Re: Serenity Amenity
Piney Grove Rawls Rd.
Fuquay-Varina, NC

The construction of the above-referenced Pool by D. Clugston Inc. has been periodically inspected by my authorized agent and found to be built to the best of my knowledge in accordance with approved plans and specifications as submitted, subject to correction of items below.

SHEET DESCRIPTION
Pool Piping & Electrical Plan

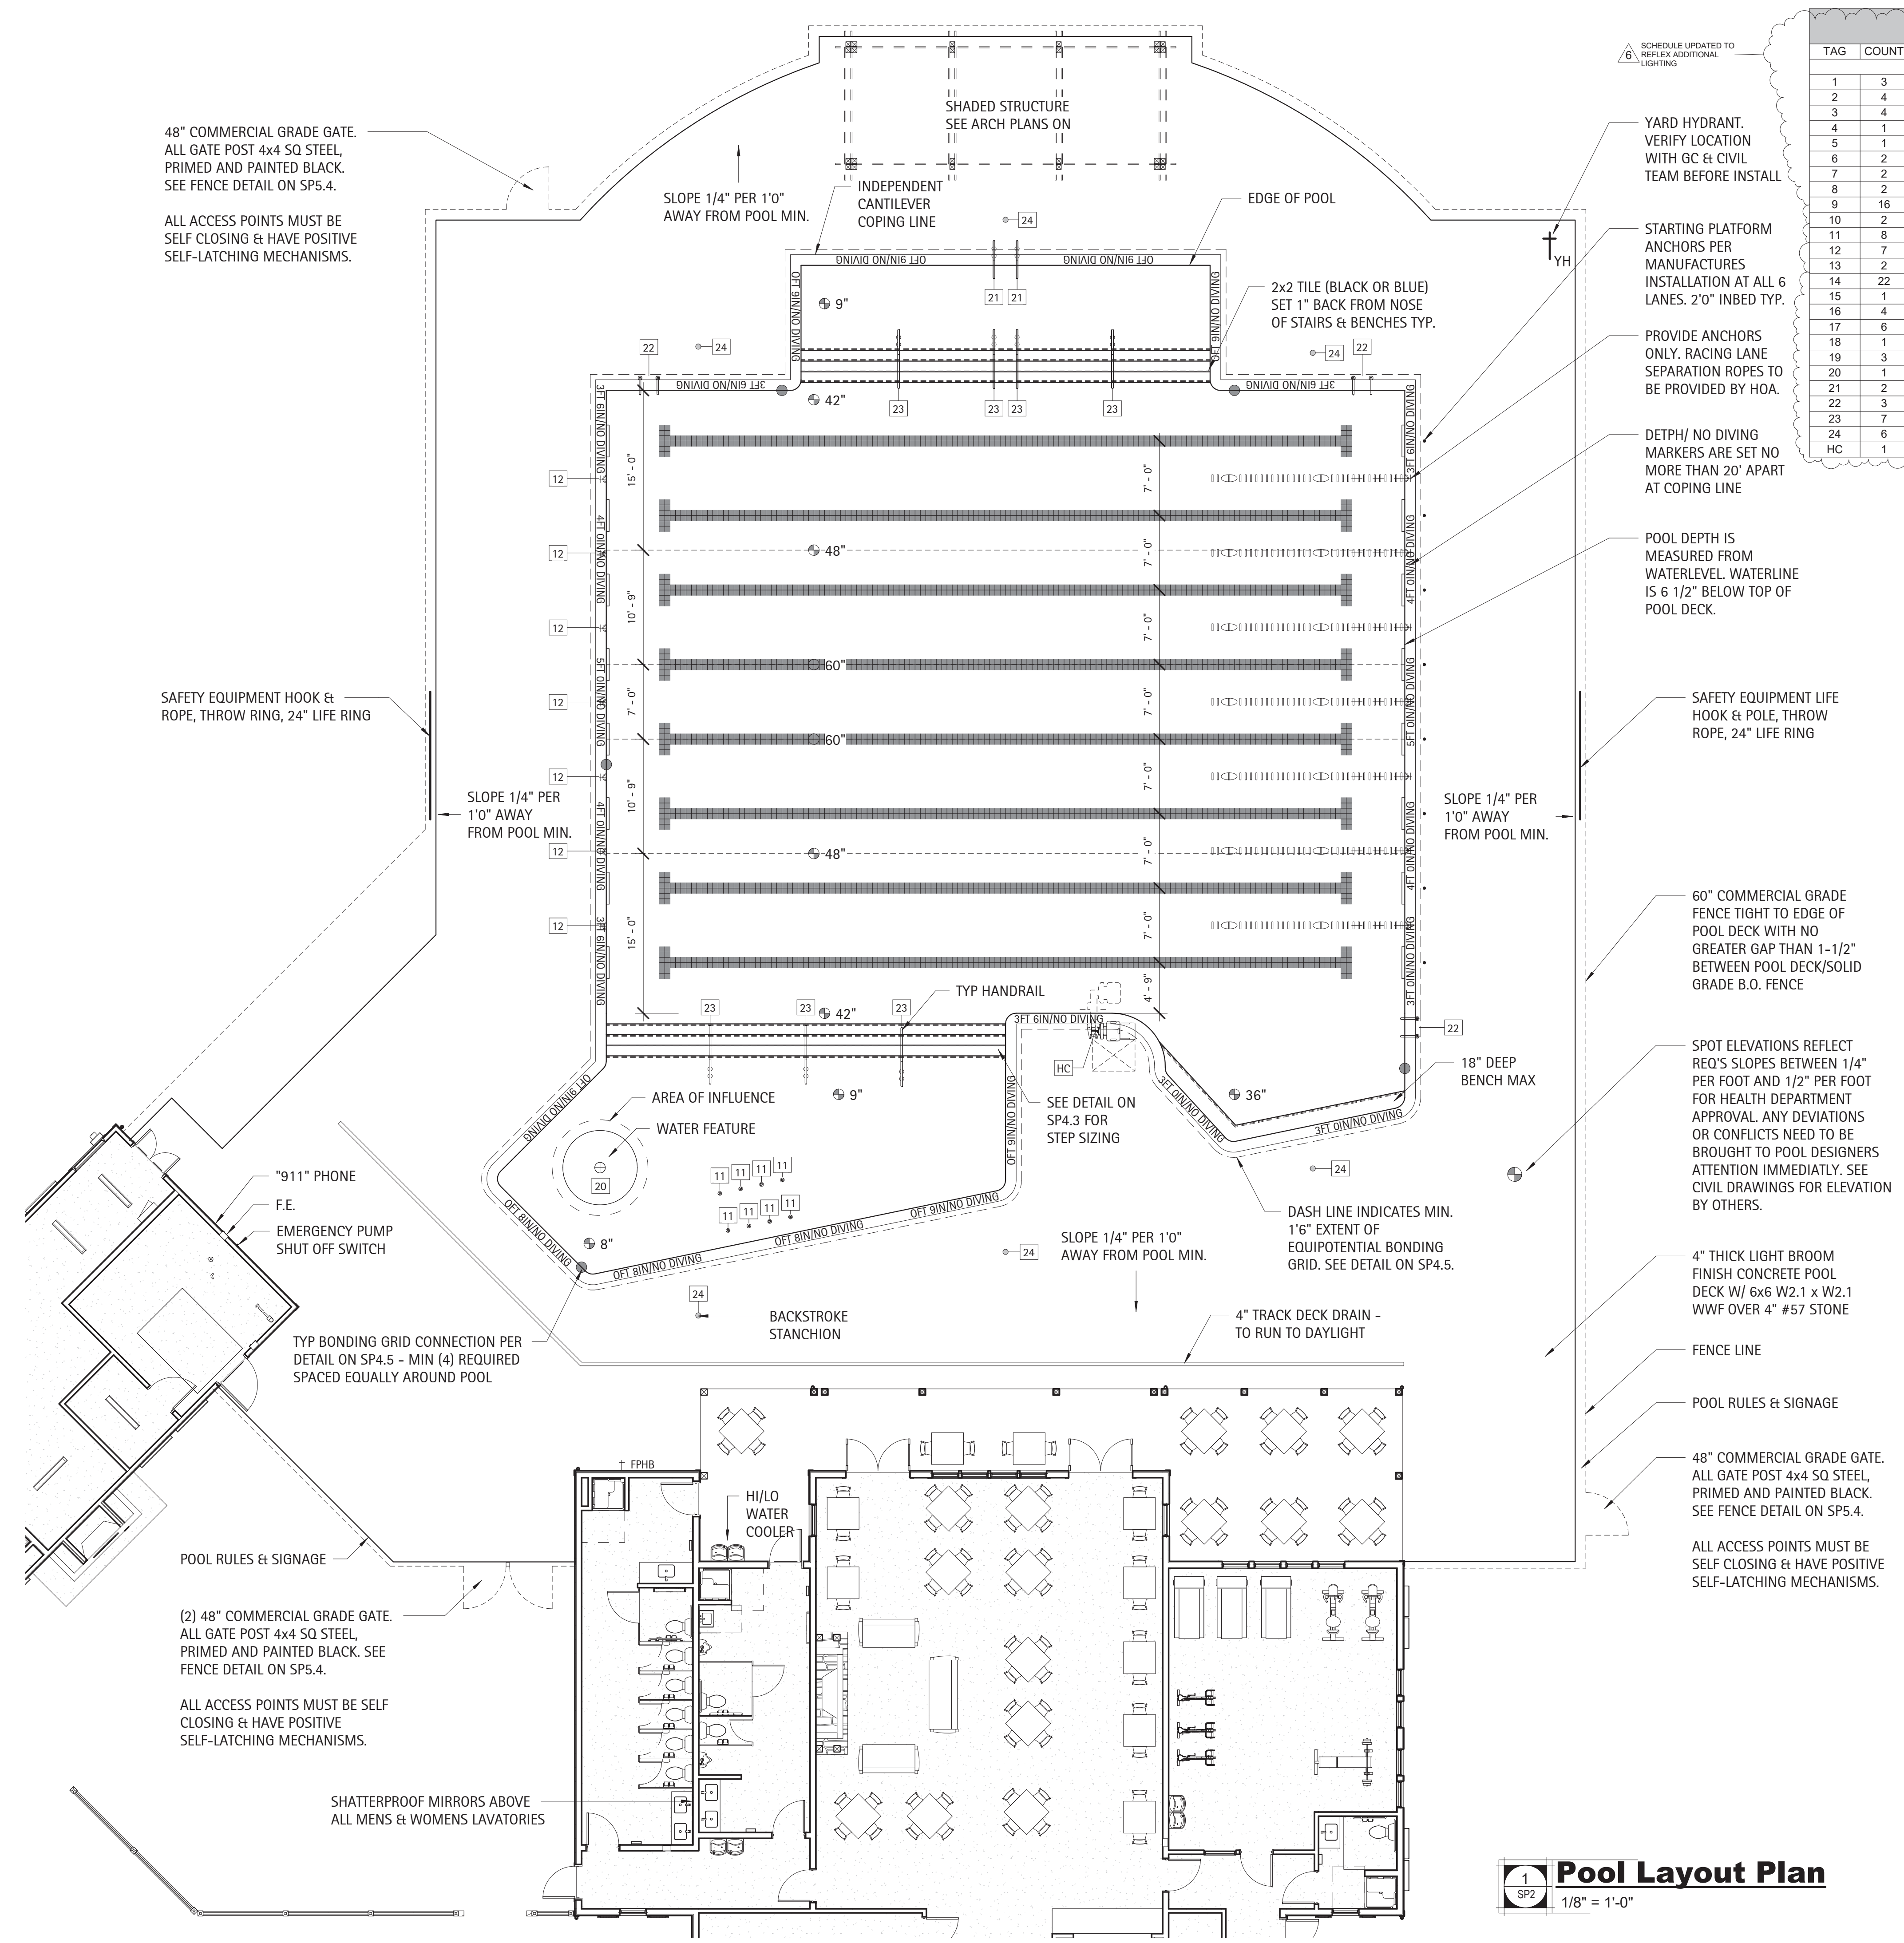
- 1) 18" x 18" Main Drain Sumps were replaced with (4) 12"x12" Main Drain Sumps due to incorrect delivered items.
- 2) Main Drain Covers for 12" x 12" Sumps updated to 1216101 (16" Retrofit Main Drain Covers).
- 3) Feature return lines were split from pumphoom into two separate lines, 3" line to mushroom & 2" line to bubblers as noted on as built plans sealed on 10/10/2022.
- 4) Two lights were added to the north side of pool as noted on as build plans sealed on 10/10/2022.
